RE: GRADING & DRAINAGE PLAN FOR OFFICE & WAREHOUSE SITE 2020  
Zearing (H18-D13)

The above referenced plan, dated July 24, 1984, is approved.

RE: TRACT D-6, GRADING & DRAINAGE PLAN DATED JUNE 18, 1981

Re: Tract D-6, Grading and Drainage Plan

CITY OF ALBUQUERQUE MUNICIPAL DEVELOPMENT DEPARTMENT ENGINEERING DIVISION				
TITLE: TRACT D-6 GRADING & DRAINAGE PLAN				
APPROVALS	ENGINEER	DATE	APPROVALS	ENGINEER
City Engineer			Liquid Waste	
A.C.E.-Design			Traffic	
A.C.E.-Hydrology			Water	
DRAWING NO.	SHEET 1 OF 1

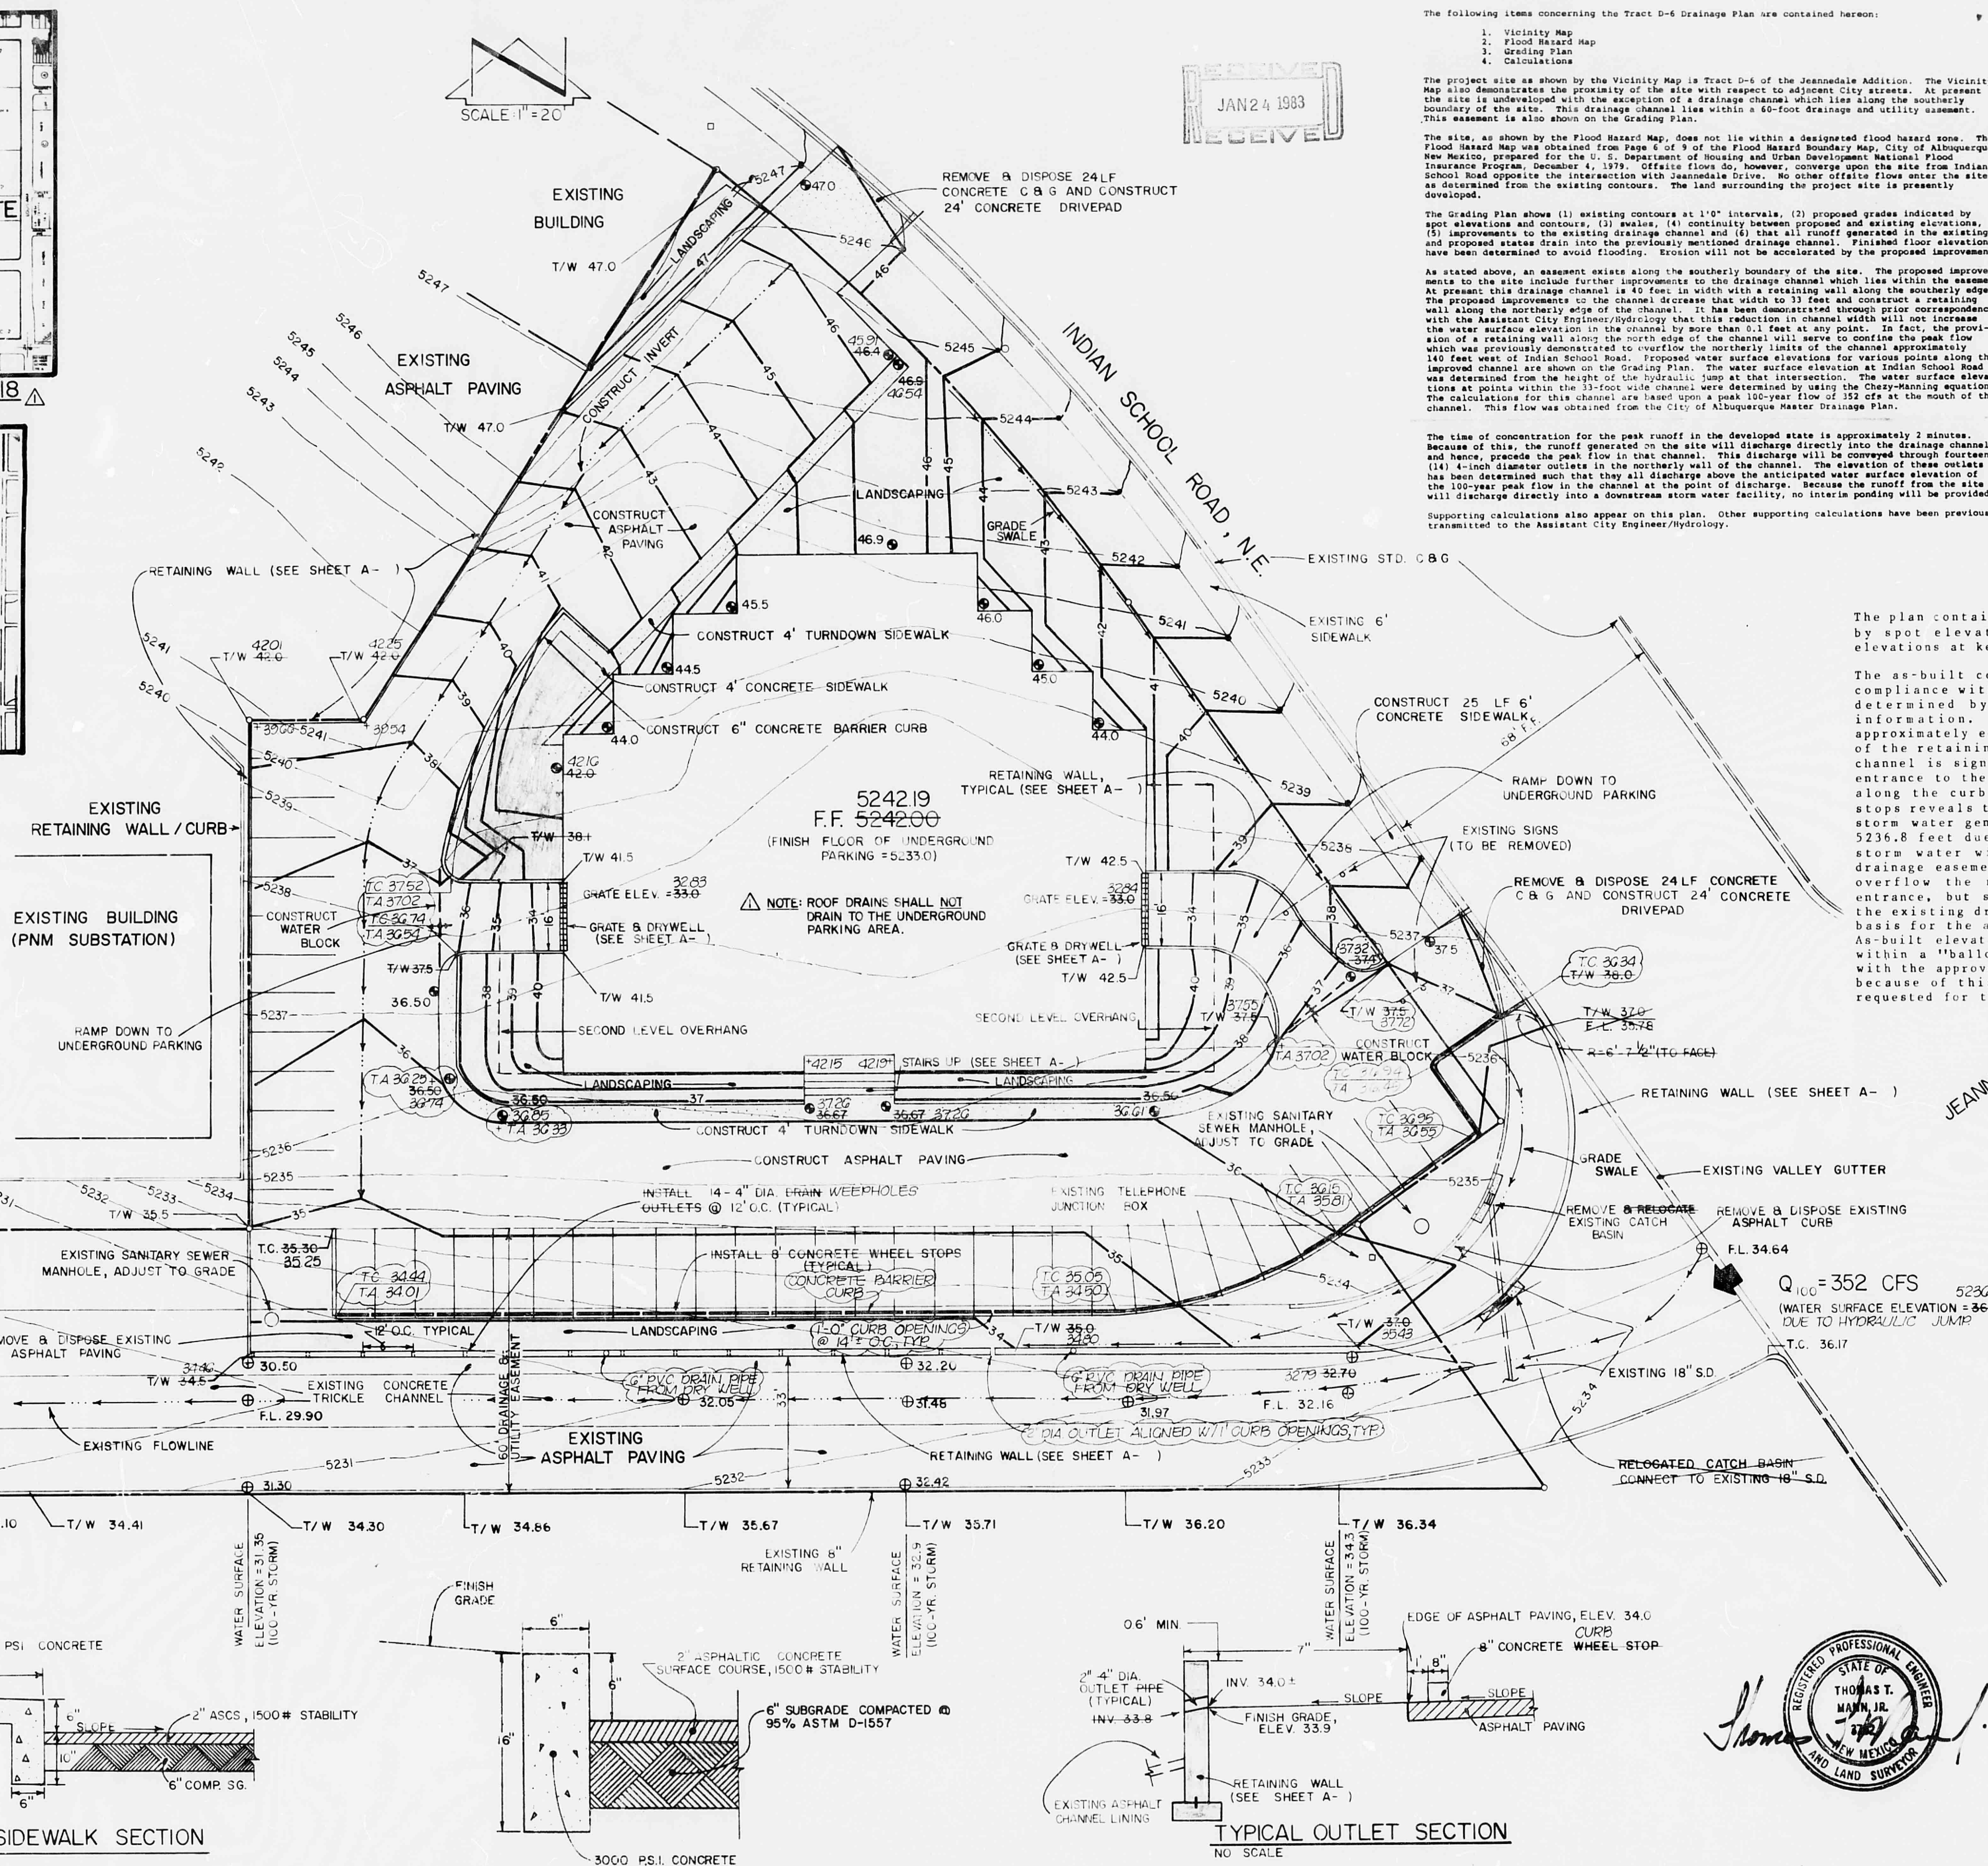
The referenced drainage report is approved with the understanding that the proposed French Drains will not be constructed within 15' of any structure. Also, a copy of the completed encroachment agreement must be submitted before the building plans are released.

1. Drive pads have been constructed to the property line.
2. The property line has been identified.
3. The Zone Atlas page has been listed.
4. Drive pads have been designed so that they are one (1) foot above the flow line of the corresponding curb and gutter.
5. A note has been added stating that "Roof drains shall not drain to the underground parking area."

Our drainage plan calls for the removal and relocation of a drop inlet on the north and west side of the drainage easement that adjoins their south boundary. I concur with Mr. Dillon that the drop inlet is not necessary. Trickle waters will go ahead and enter the drainage easement and be picked up near the freeway, rather than go into this inlet. I do not feel that this is a critical item and that the drop inlet could be deleted.
